RE: West Mesa Ridge Apartments
701 Coors Blvd NW
Albuquerque NM, 87121

Traffic Circulation Layout – Corrections Delta 1

TCL1.0

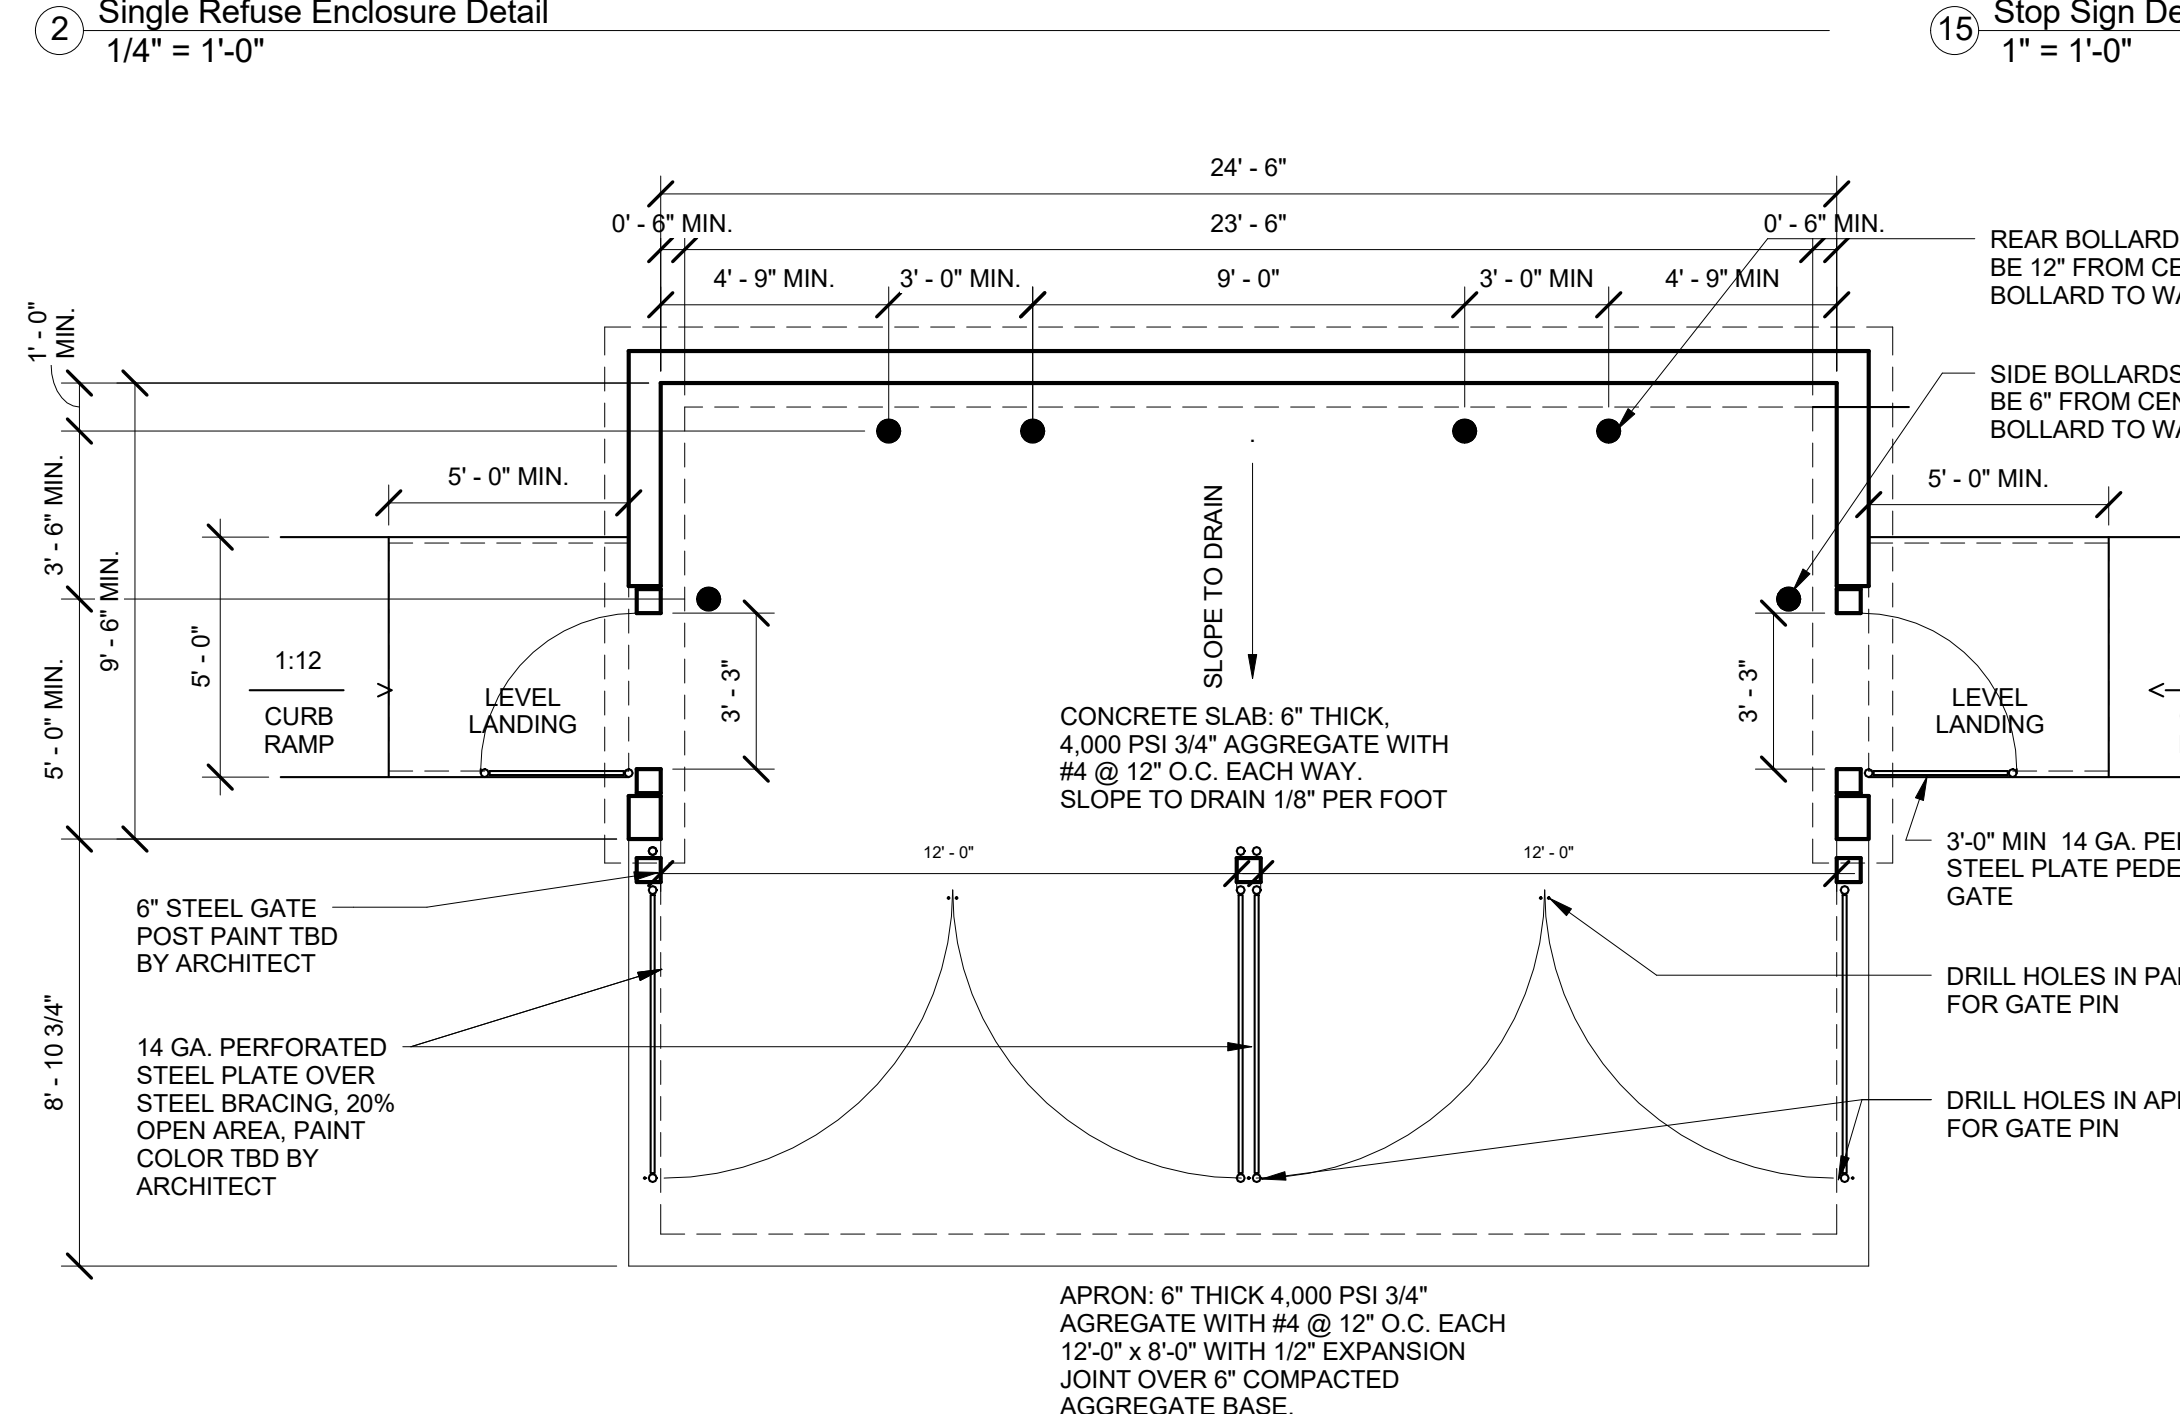
2. Show the location / details of main entrance to the facility.
A new keynote was added (39) to identify main entry into residential buildings. Keynote 15 was edited to show main entry into community building.

5. Provide the hatch legends
A hatch legend showing concrete and clear sight triangle has been added to the updated TCL.
6. Show the number of spots for motorcycle parking and bike racks required by IDO in the plan.
I updated the parking count to include motorcycle and bicycle parking spaces. Please see keynote 13 and 35.

12. Show all drive aisle widths and radii. Some dimensions are not shown.
The updated TCL now shows aisle widths, sidewalk widths, and radii throughout.

14. List radii for all curves shown; for passenger vehicles. Radius for delivery trucks, fire trucks, ect. Is 25 ft or larger.
The attached TCL has been updated to show radii for curves throughout the site. The roundabout radius exceeds the minimum requirements per the table that was shared on the original TCL Comment Document.

West Mesa Ridge	701 COORS BLVD NW ALBUQUERQUE NM 87121
sheet no:	
TCL2.1

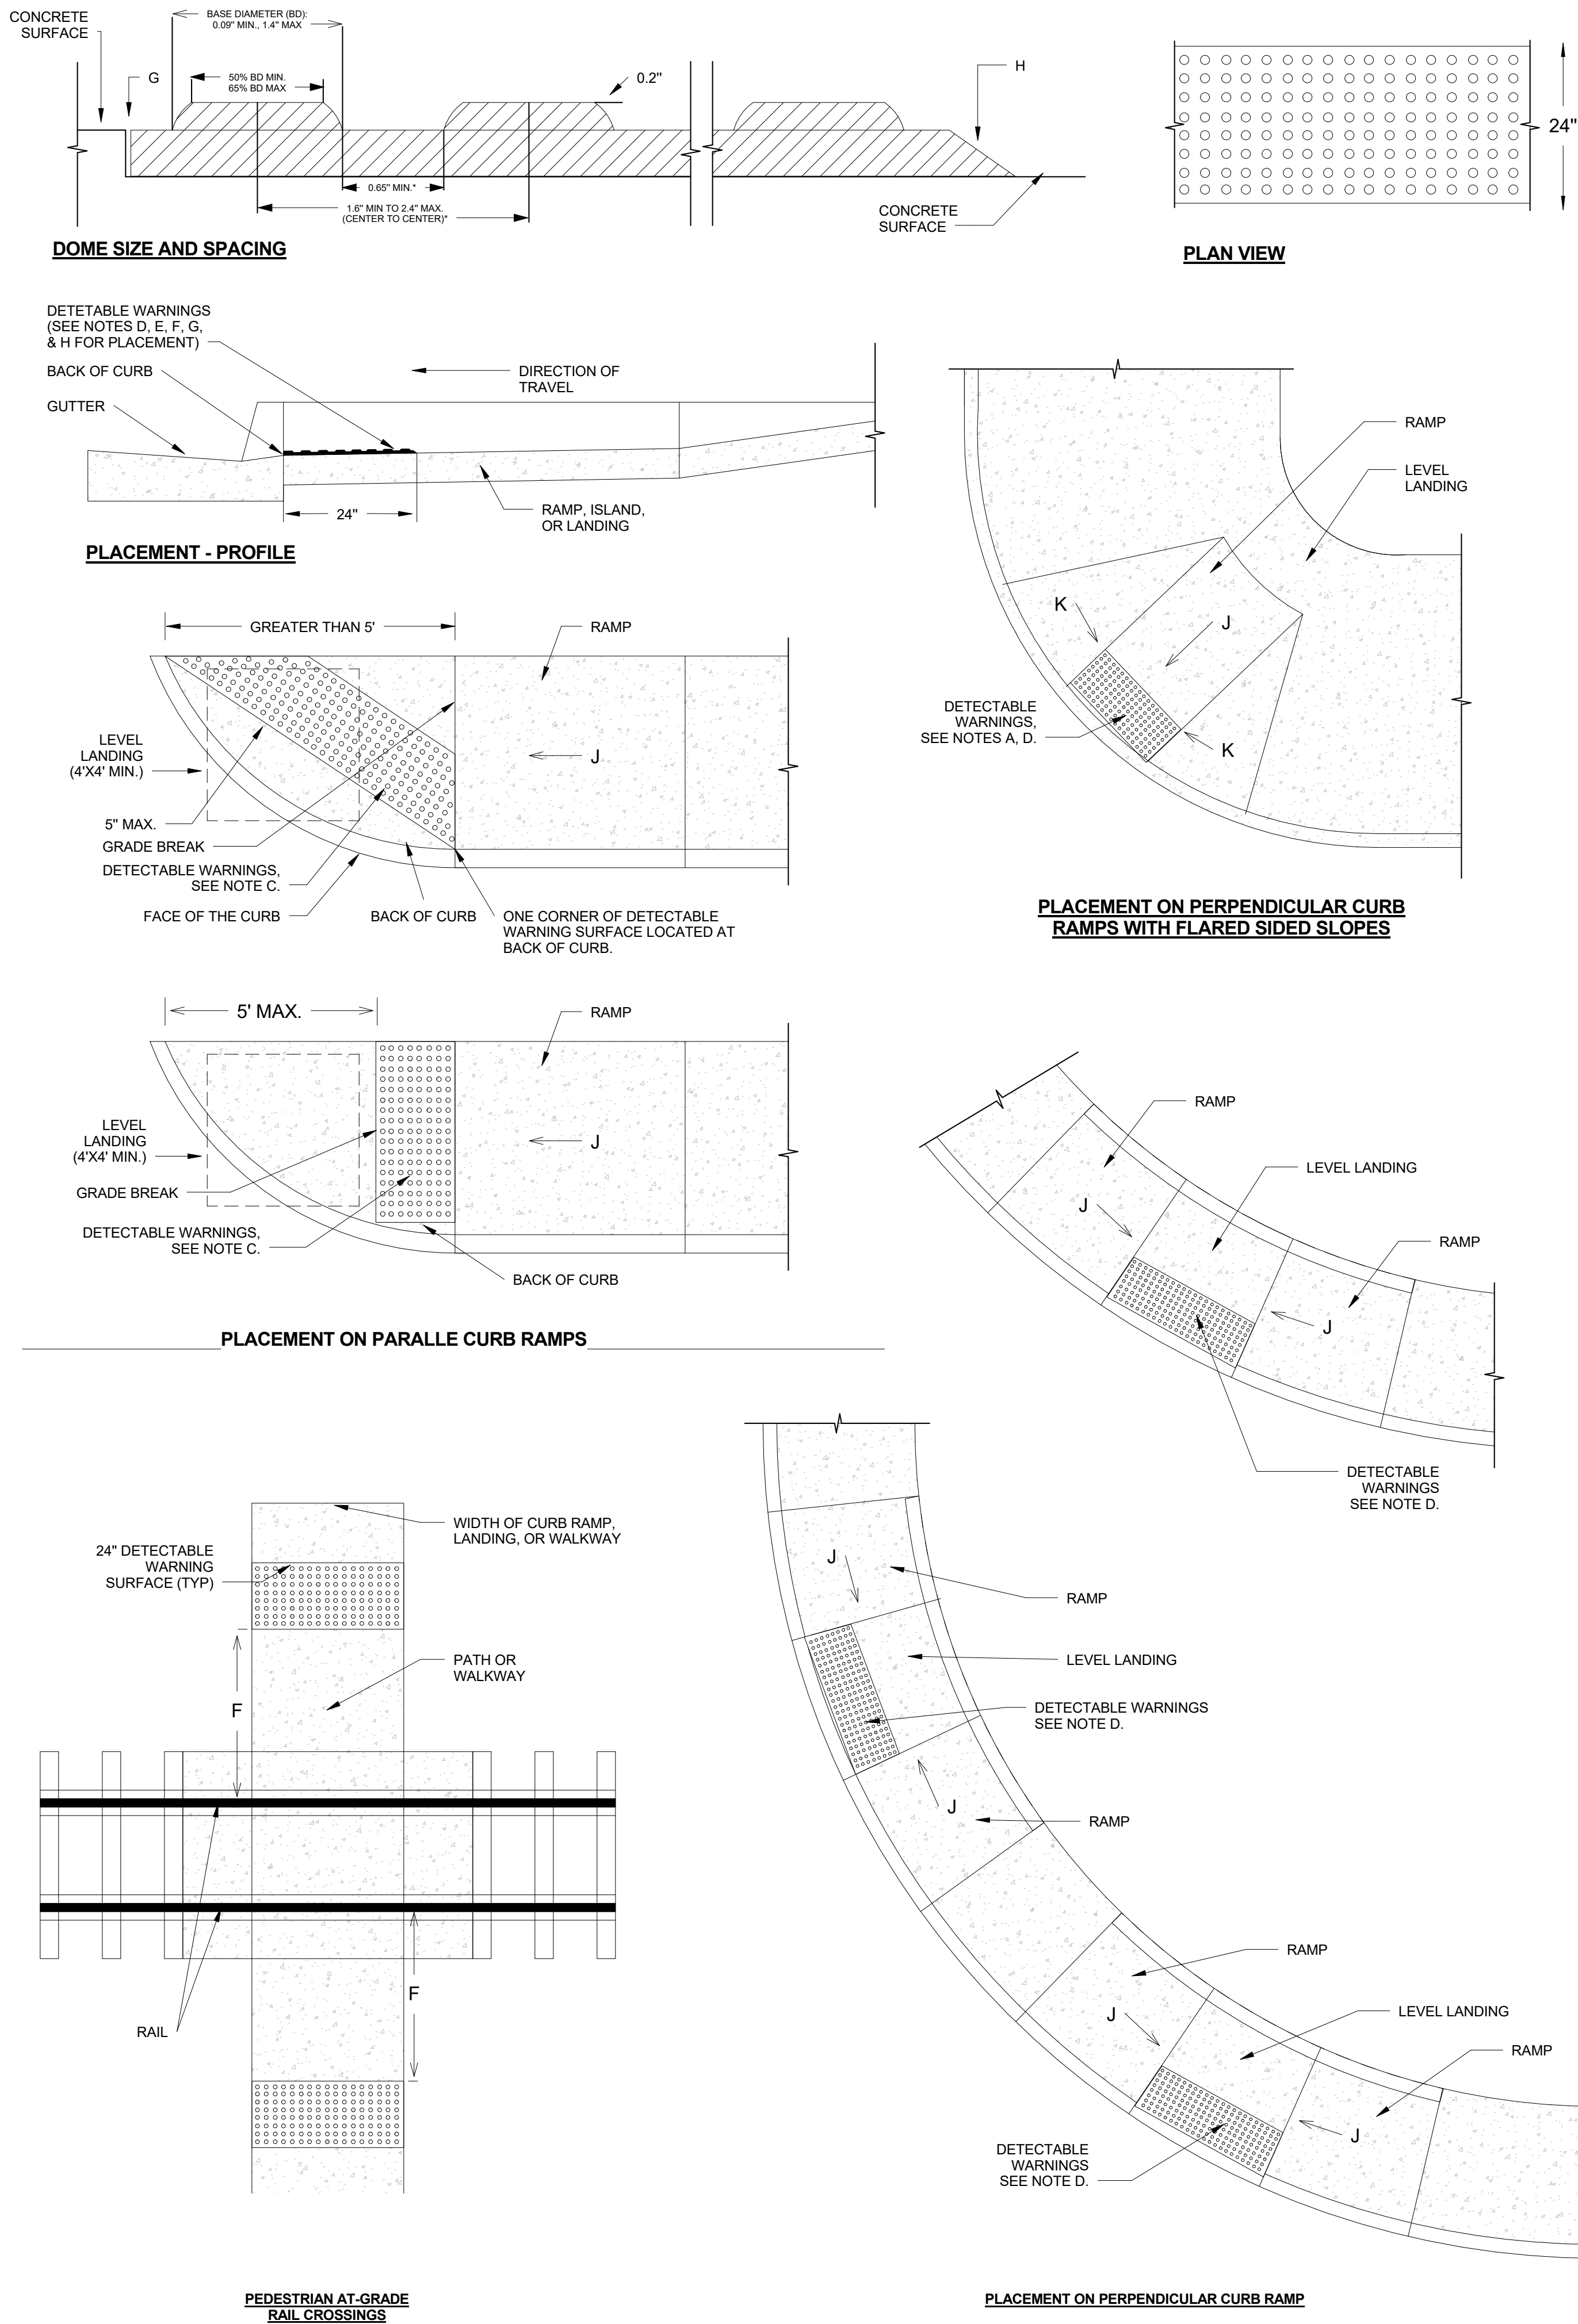
4. Provide the sidewalk easement for this corner: Also, ADA curb ramps must be constructed as per current standards and have truncated domes installed.
Any easements necessary will be obtained prior to the approval of Final Plat. As a clarification, truncated domes are only required on public curb ramps per General note 1 of DWG 2446 of the City of Albuquerque Standard Specification Volume 2 Section 2400.
